# Markup Summary

dsdparsons (31)

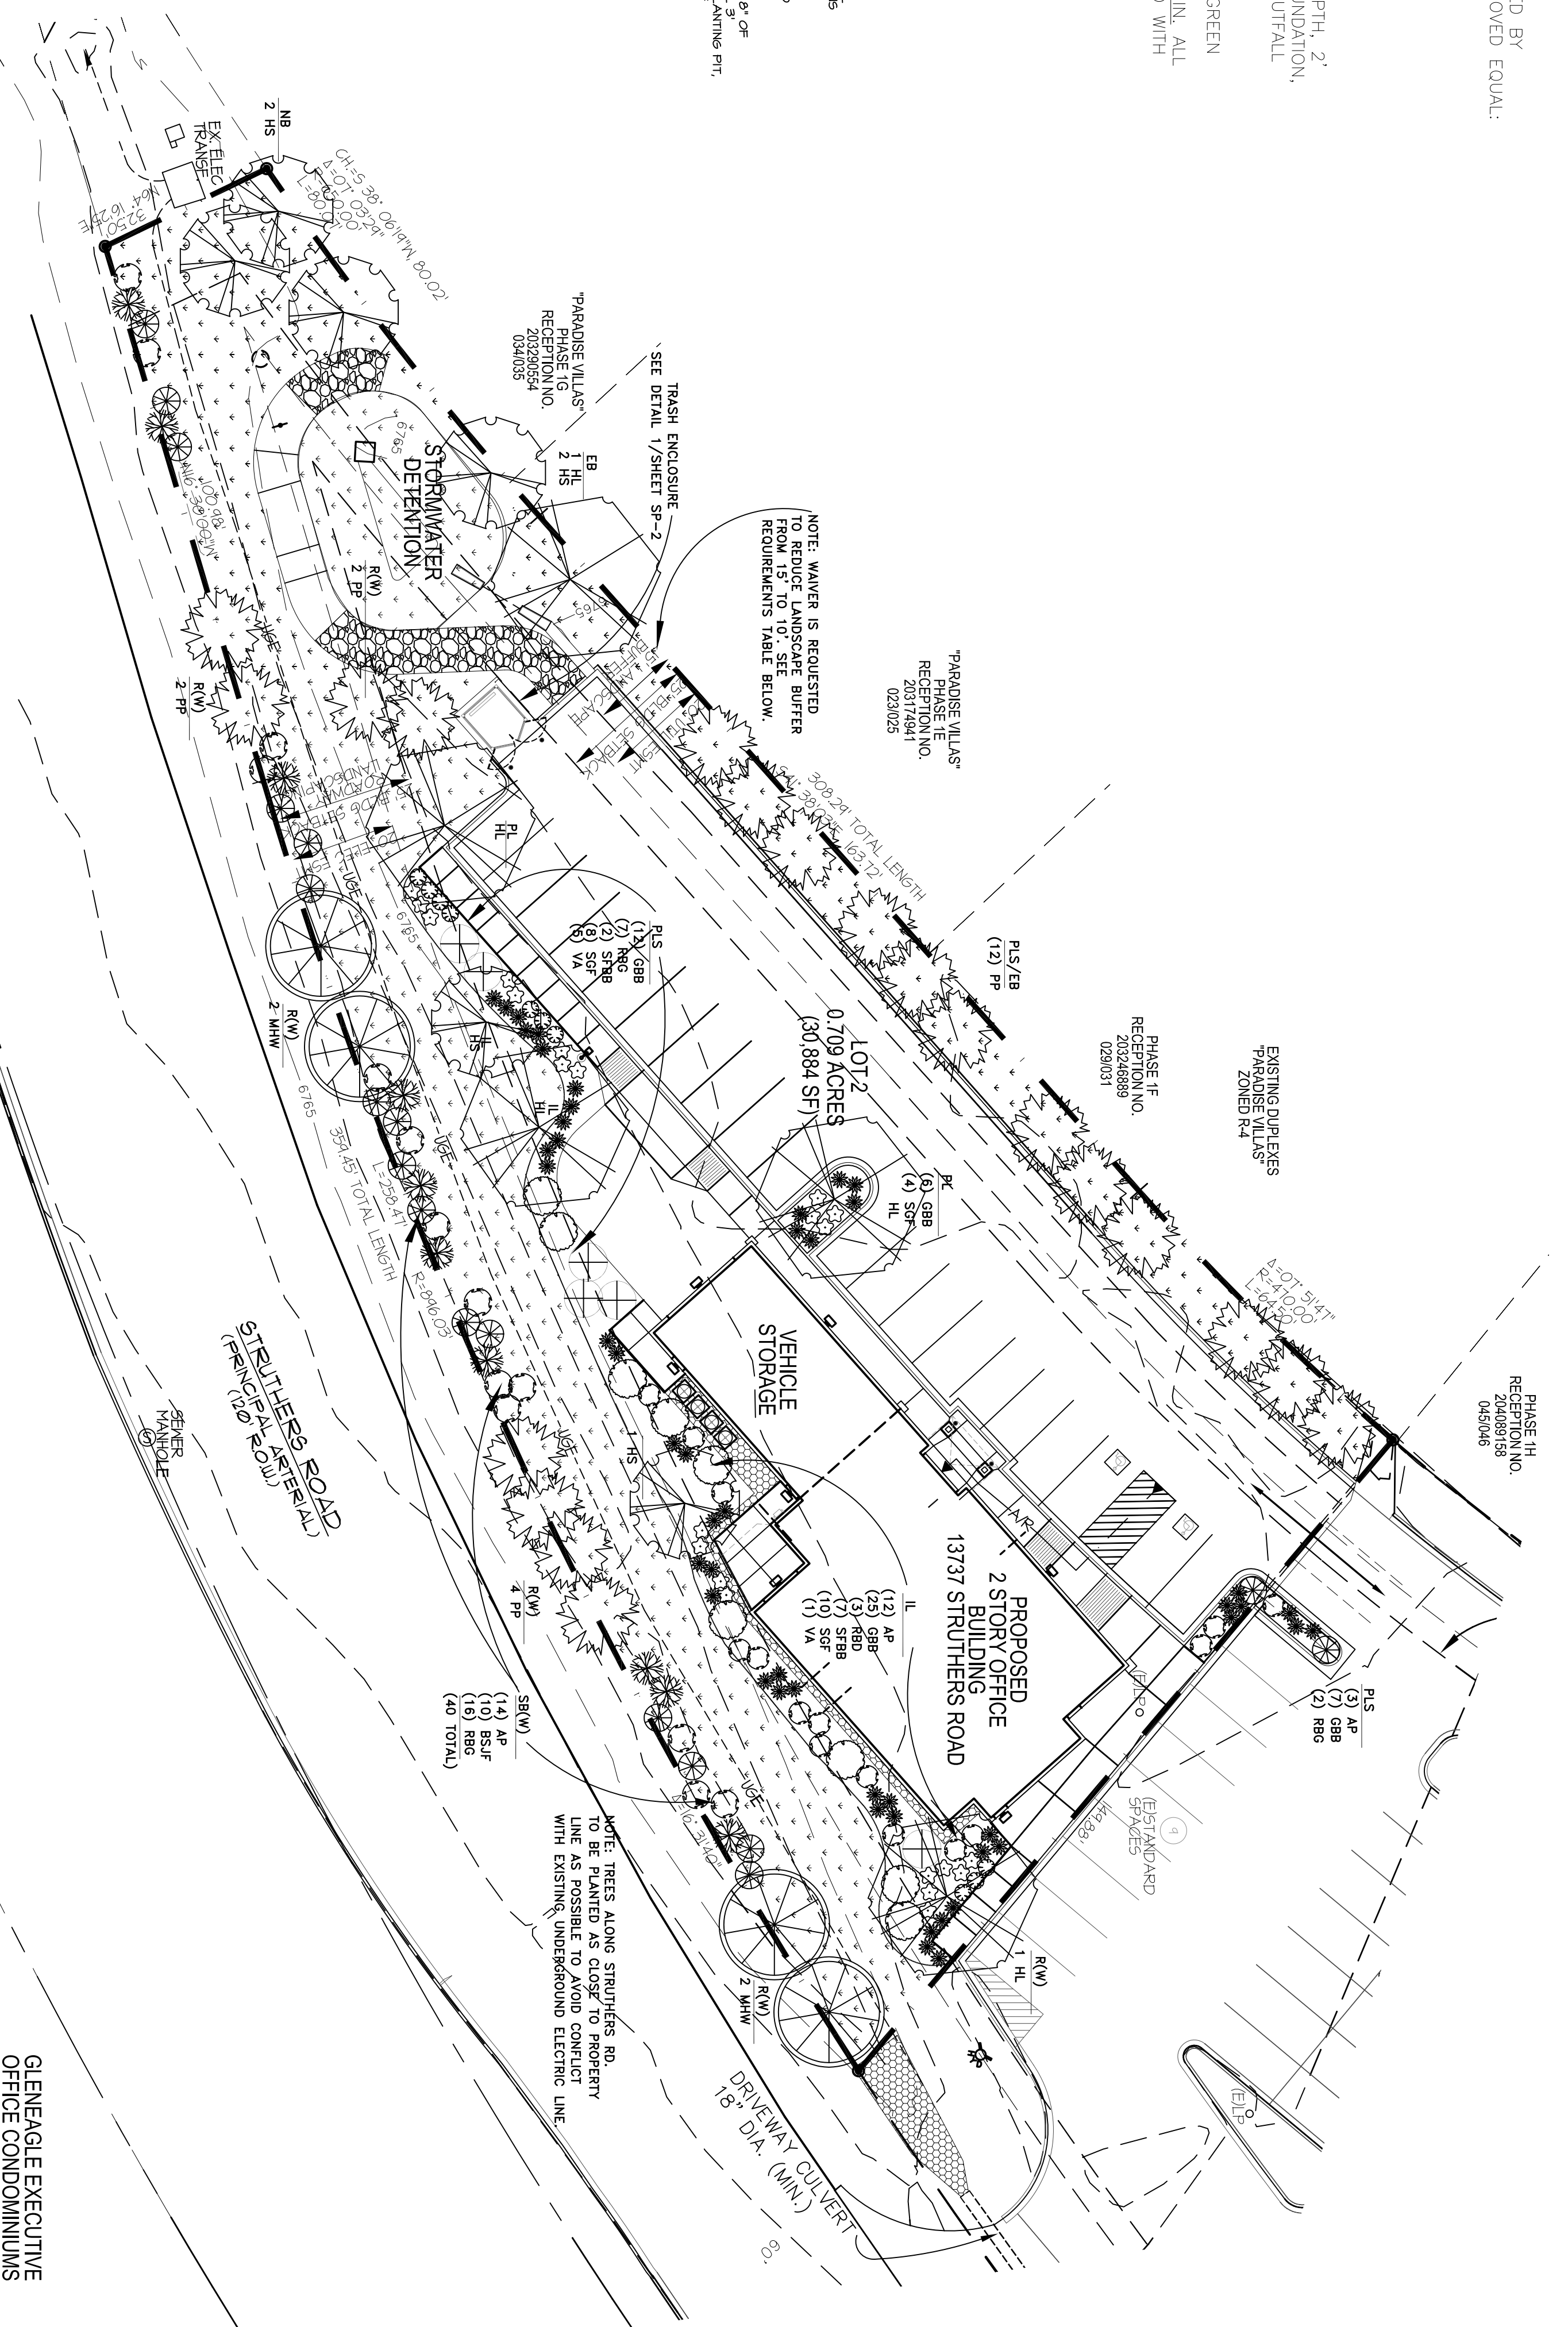
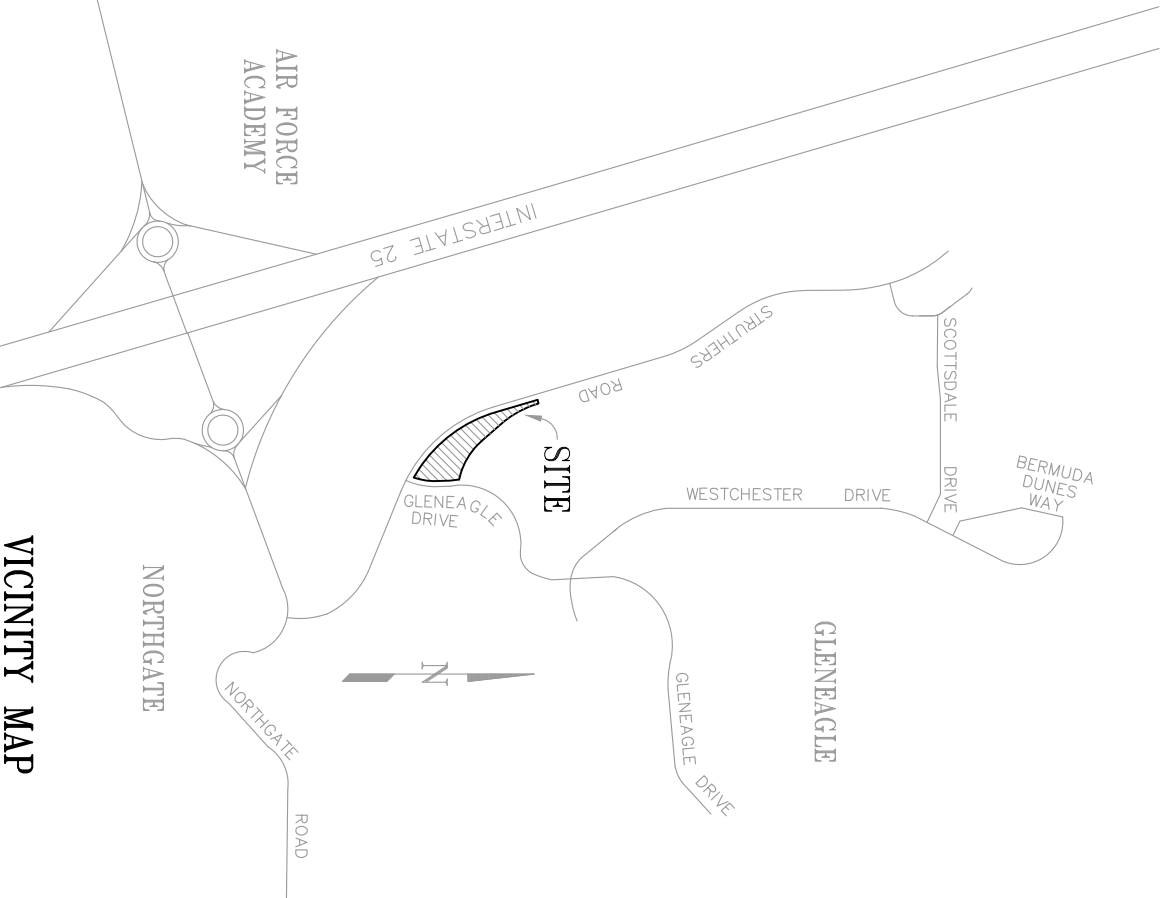
If the lot is 30000SF divided by 500 SF that's incorrect see 6.2.2.E.3.c internal area calculation

Opaque screening is required provide detail

what unit of measure is this?

what is the lot size?

parking lot islands are required per 15 spaces-  
LDC 6.2.2.C.2 Please add

15 feet is the buffer setback and the requirement is  
1 tree / 25' with 1/3 evergreen please break out.  
see chapter 6, buffer requirements

Paradise Villas Buffer (entire length of property (this lot))

Check length of the property line for each boundary from plat for lot 2-listed length is incorrect.

Remove this is not required in the roadway tree category 6.2.2.B table 6-1

Break into N S E W -it is unclear which screening is being identified there should be 3 sides to screen. If we call the paradise villas the east and the north property lines, Struthers road the west property line, then the south would need screening for 18' (a single parking space) screening.

Buffer IS required, 6.2.2.D.2. Please provide. zone boundary is excepted out when Buffer requirements are required which are more restrictive

The north piece is part of the residential development the 25' buffer is applicable on the north end

Provide fence detail please for trash enclosure

Adjust accordingly Please

Building and landscape setback

Building setback is 25' the landscape setback Buffer is 15' at N and E prop lines

Dimension all lot 2 property lines (please see recently approved plat)
